PROJECT:	CHIEF MECHANICAL ENGINEER'S BUILDING		
Sketch Title:	FIRE - Spatial Markup Sketch (Sheet 1 of 3)		
Sketch No.:	SK-F-0001		
Date & Revision:	18/10/22	Rev A	By: A.KOIRALA
Scale:	AS PER DRAWING	Reason for Issue:	For Coordination
<small>This document is not for tendering or construction purposes. GHD does not warrant or represent that the information is sufficient, accurate, or complete.</small>

PROJECT & CLIENT
RNE - Chief Mechanical Engineers Building
FIRE SERVICES
 Transport for NSW

FIRE SERVICES GROUND FLOOR LAYOUT

GROUND FLOOR PLAN
1:100

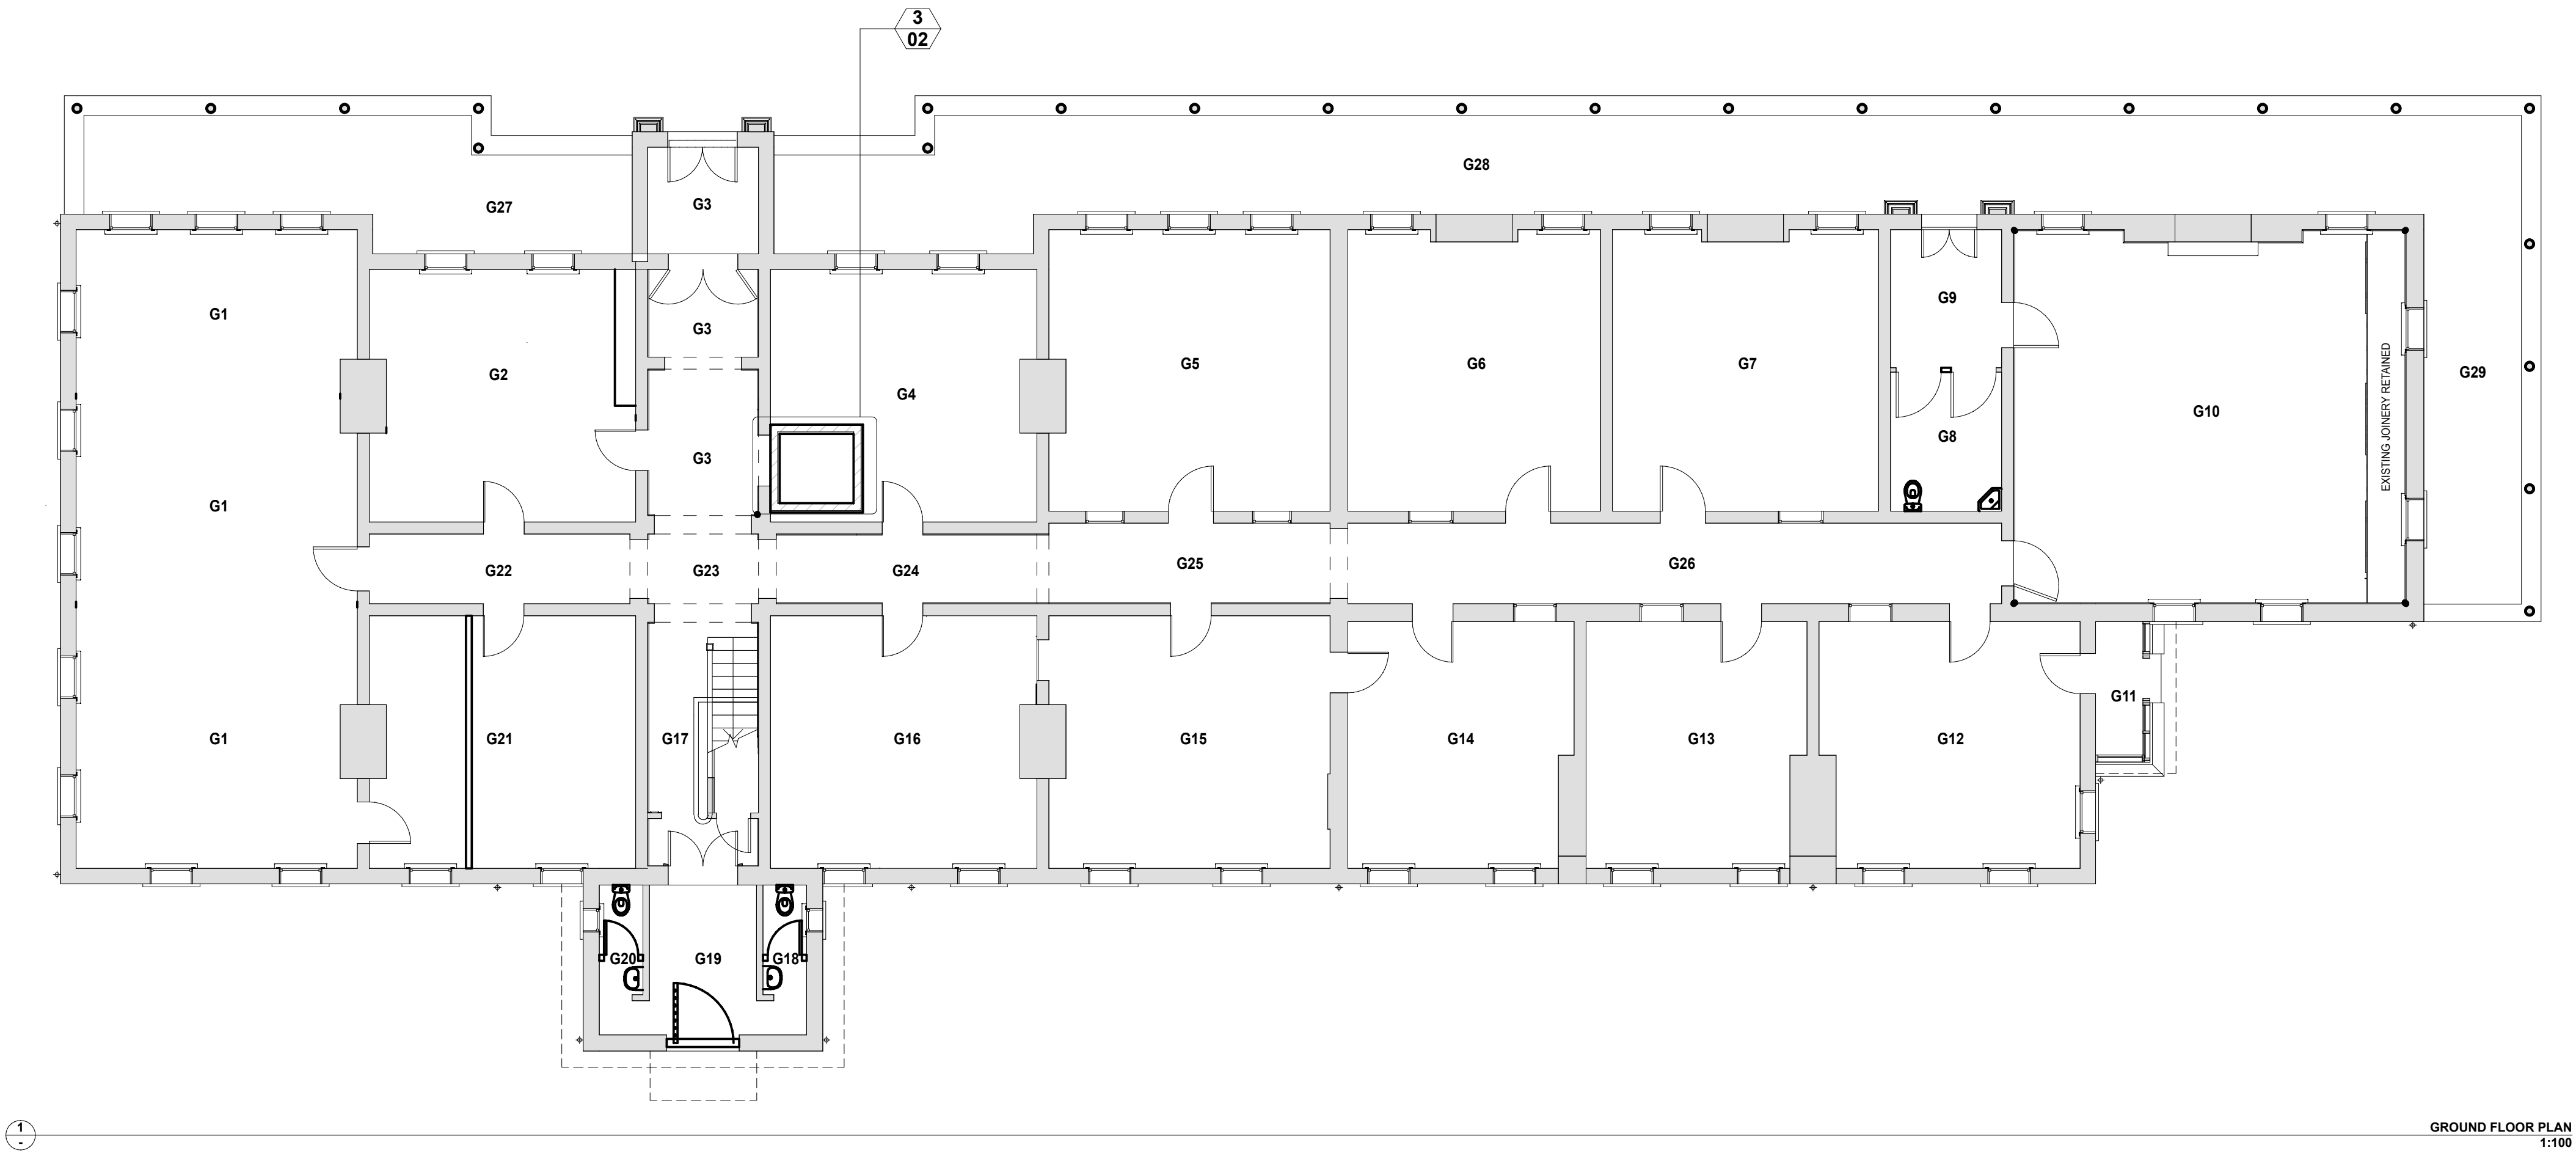
NOTE: FIRE HYDRANT CAN BE DELTED BASED ON PERFORMANCE SOLUTION WITH 3 HOSE LENGTH.

FIRE HYDRANT 100mm (W) X 800MM(D) (TYPICAL) WITHIN 4M OF THE EXIT DOOR

FIRE PANEL 650 (W) X 450 (D) X 1000mm (H) (500mm CLEARANCE ON EITHER SIDE AND 1m IN FRONT OF THE PANEL)

FIRE HYDRANT 100mm (W) X 800MM(D) (TYPICAL) WITHIN 4M OF THE EXIT DOOR

SMOKE DETECTION AND WARNING SPEAKERS THROUGHOUT

SPR 80 RISE FROM UNDER FLOOR TO GROUND FLOOR CEILING TO LEVEL 1.

SIDEWALL SPRINKLER HEAD FOR BALCONIES.

SPRINKLER TO EACH INDIVIDUAL ROOMS.

SPRINKLER MAIN TO RECITULATE ON GROUND FLOOR HIGHLEVEL

SPRINKLER PIPE TO RUN IN FIRST FLOOR FLOOR JOIST/ STRUCTURE IN DIRECTION OF THE JOIST TO BE DETAILED

FIRE SPRINKLER VALVE ROOM. 2M X 1 M. REQUIRE FLOW TEST PIT 7L/S TO DISCHARGE TO STORMWATER.

CURRENT LOCATION NEED PERFORMANCE SOLUTIONS
 1. DOESNT OPEN DIRECTLY TO THE OPEN SPACE.
 2. SERVICES BELOW THE EGRESS STAIR(CONFIRM THIS WITH BCA CONSULTANT).

FIRST FLOOR PLAN
1:100

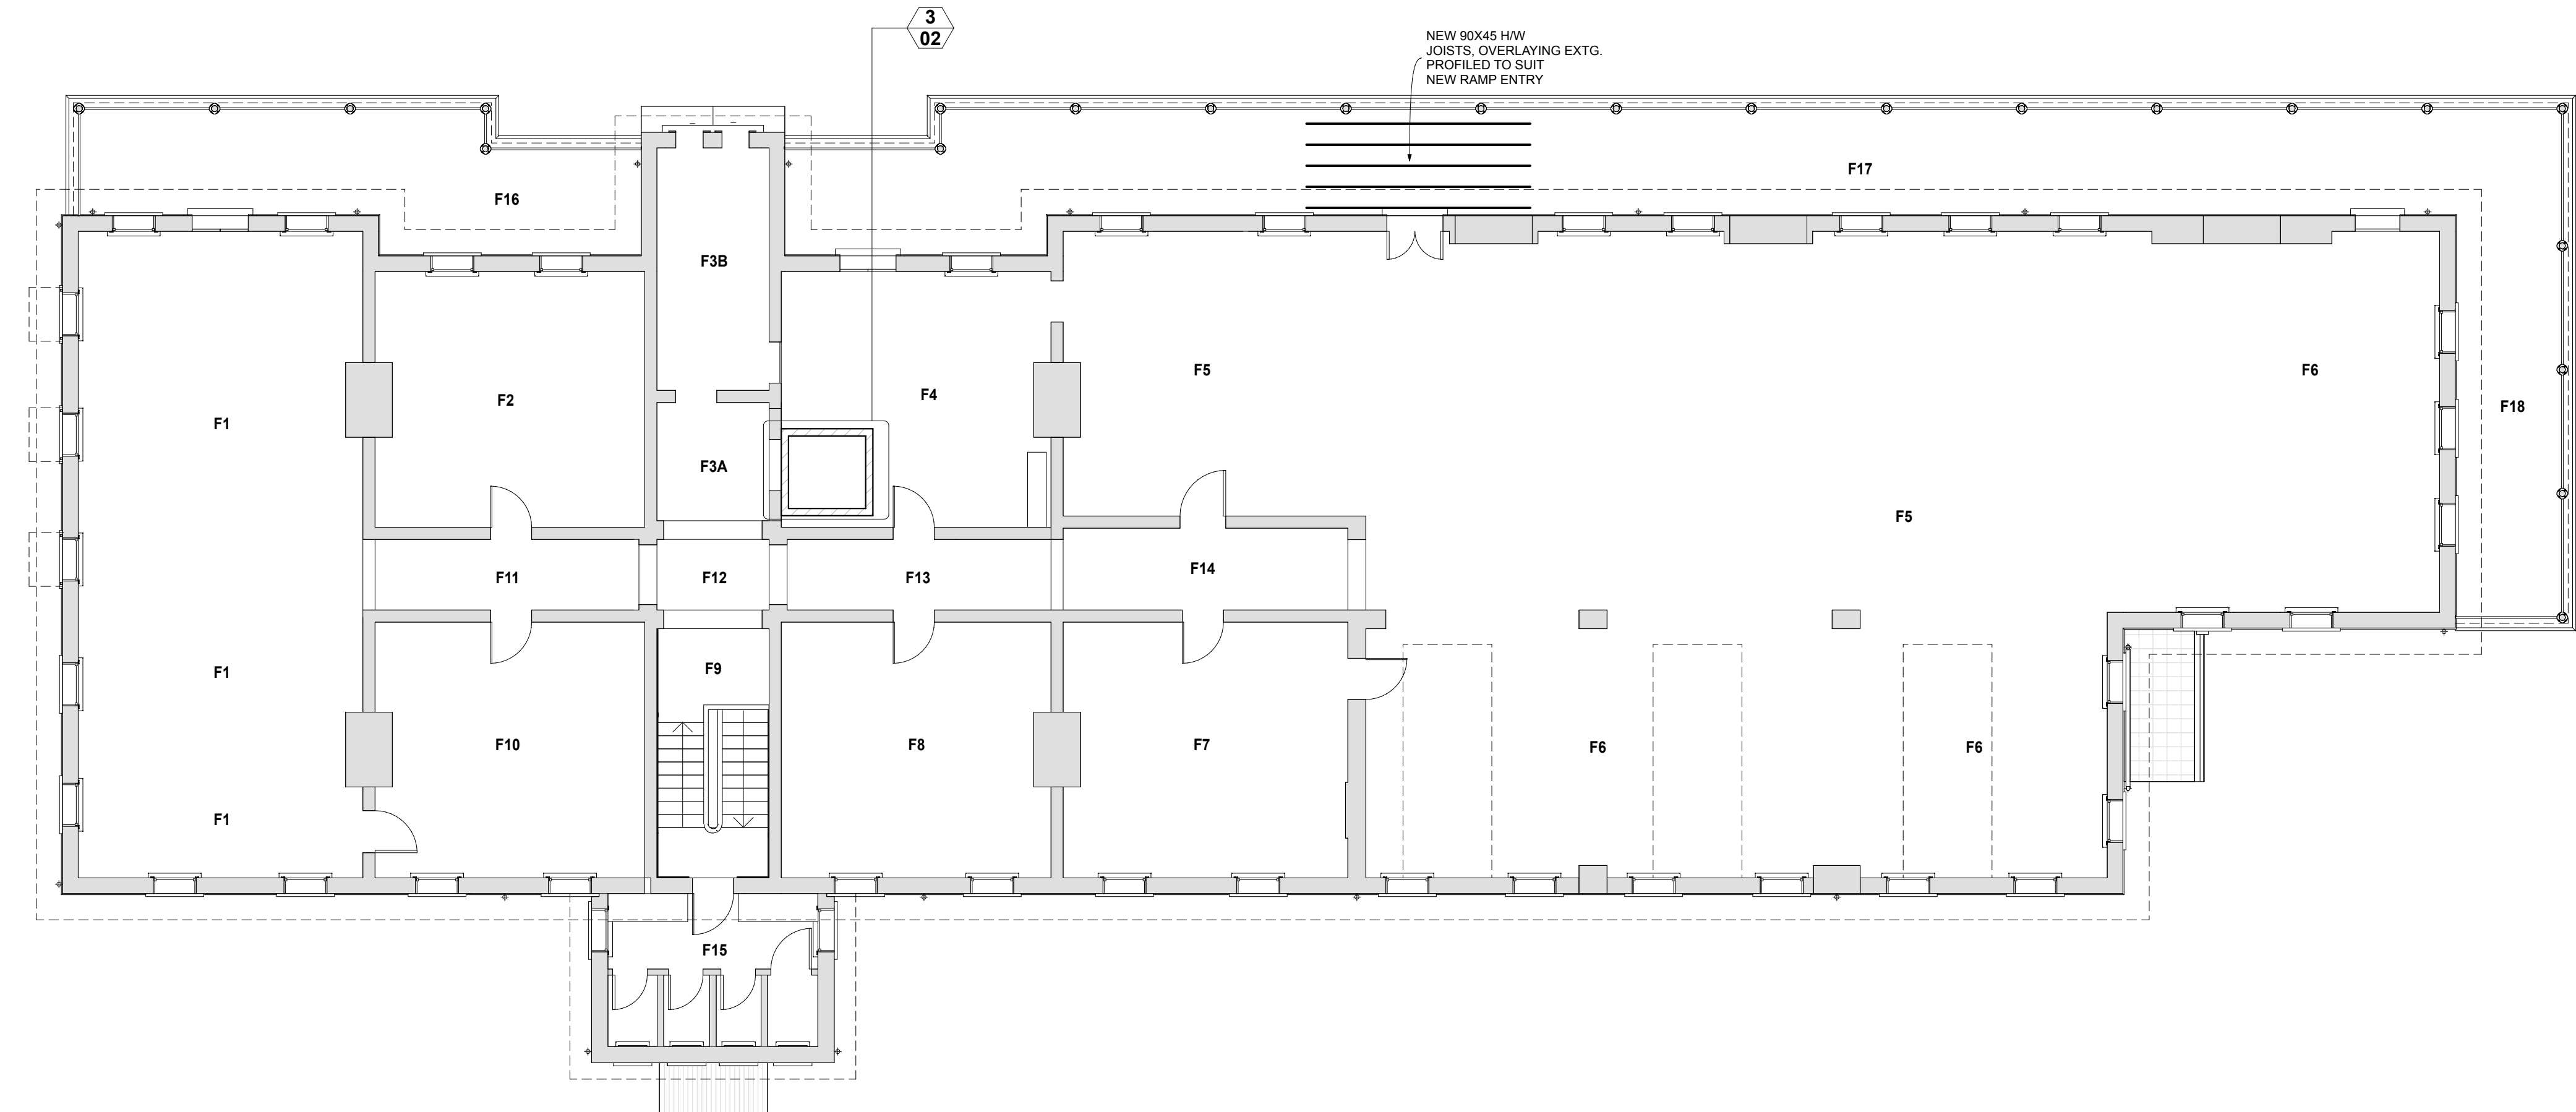
NOTE: FIRE HYDRANT CAN BE DELTED BASED ON PERFORMANCE SOLUTION WITH 3 HOSE LENGTH.
